Department of Transportation

March 10, 2021

RE: Falcon Fields Preliminary Plan Review - SP211

### COVERSHEET

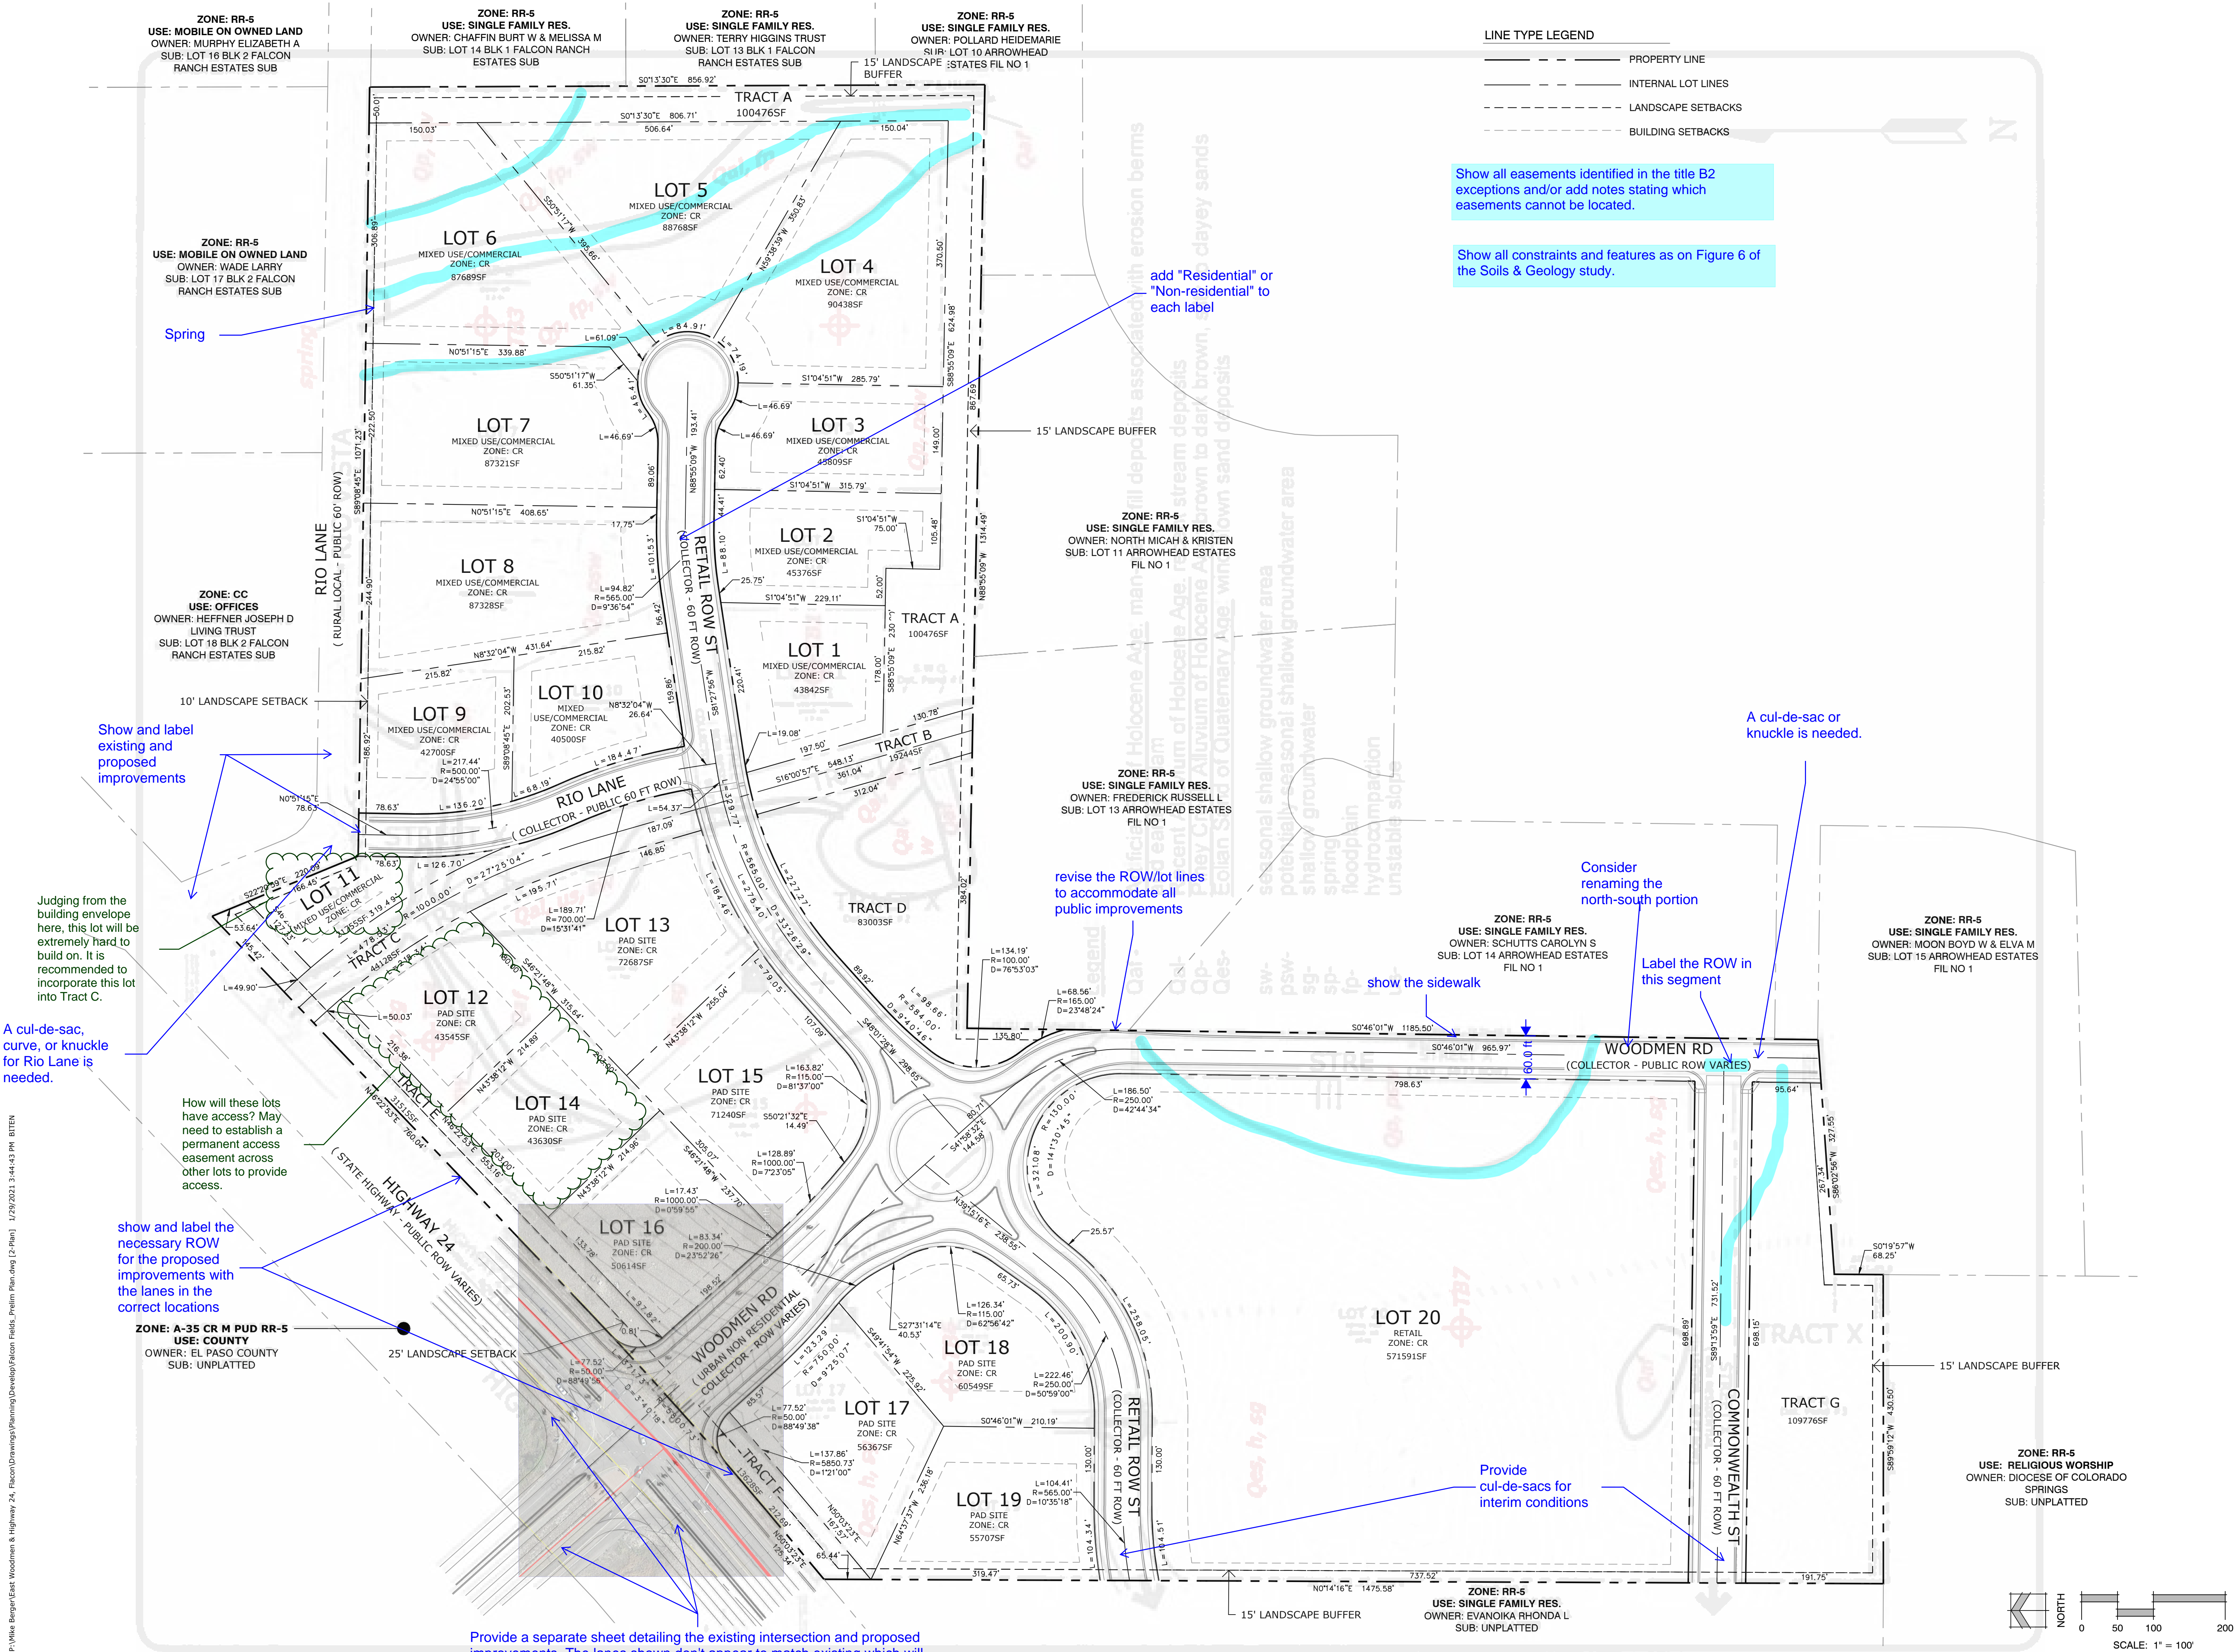
- Provide a drainage report to review.
- Need to ensure the development has adequate setback from CDOT ROW to ensure no conflict with the future US24 widening. May need to have their engineer work directly with my PEL team to achieve this. Plan needs to clearly show ROW/easement lines.

Deviation Exhibit C

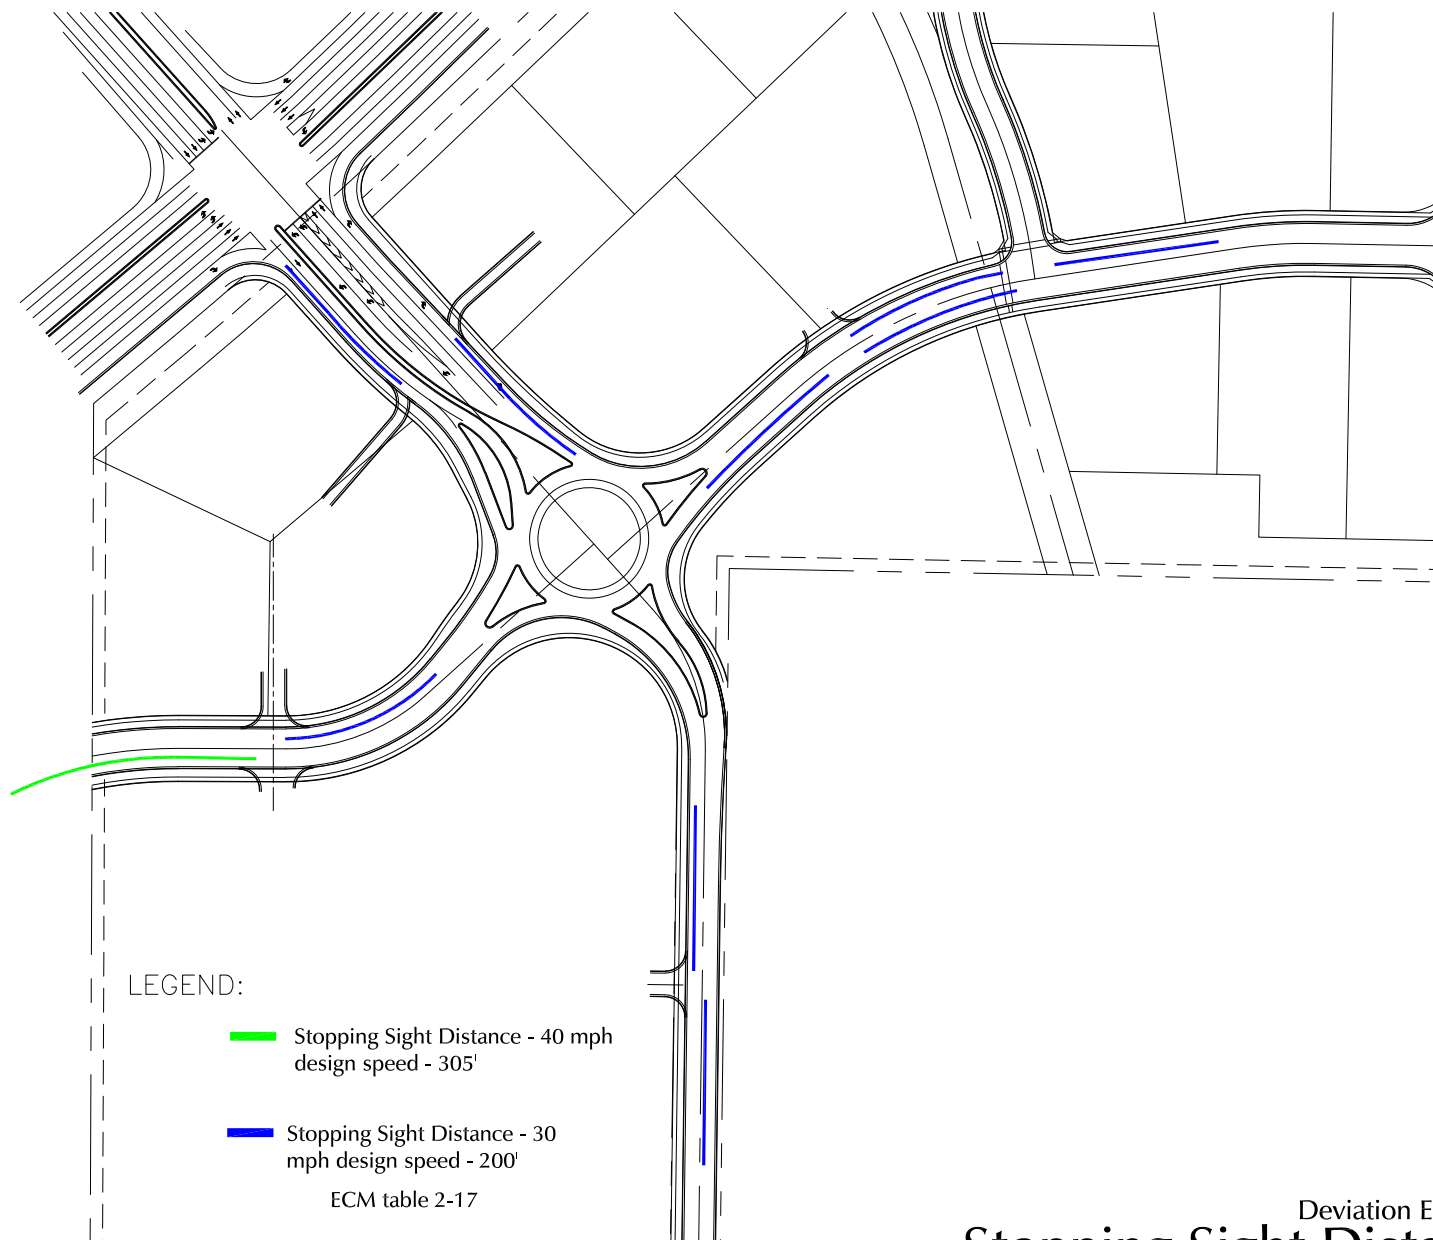
- **On US24:**
 - Closure of Rio Ln. connection to US24.
- **On US24 at Woodman:**
 - Construct a northeast-bound right-turn deceleration is warranted on US Hwy 24 approaching Woodmen Road. Based on a posted speed limit of 55 mph, the prescribed lane length for the deceleration lane is 600 feet plus a 222-foot taper.

- Construct a southwest-bound left-turn deceleration is warranted on US Hwy 24 approaching Woodmen Road. Based on a posted speed limit of 55 mph, the prescribed lane length for the deceleration lane is 600 feet plus 150 feet of storage and a 222-foot taper.

- Extend the southwestbound left-turn deceleration lane plus transition taper on US24 (westbound) approaching Woodmen Road to 750 feet.
 - Construct a northwest-bound right-turn acceleration is warranted on US Hwy 24 east of Woodmen Road. Based on a posted speed limit of 55 mph, the prescribed lane length for the acceleration lane is 960 feet plus a 222-foot taper

- Lengthening/extension of the westbound right turn deceleration lane on US Highway 24 at Woodmen Road to CDOT standards (600 feet plus transition taper) with the necessary widening of the box culvert under US 24.
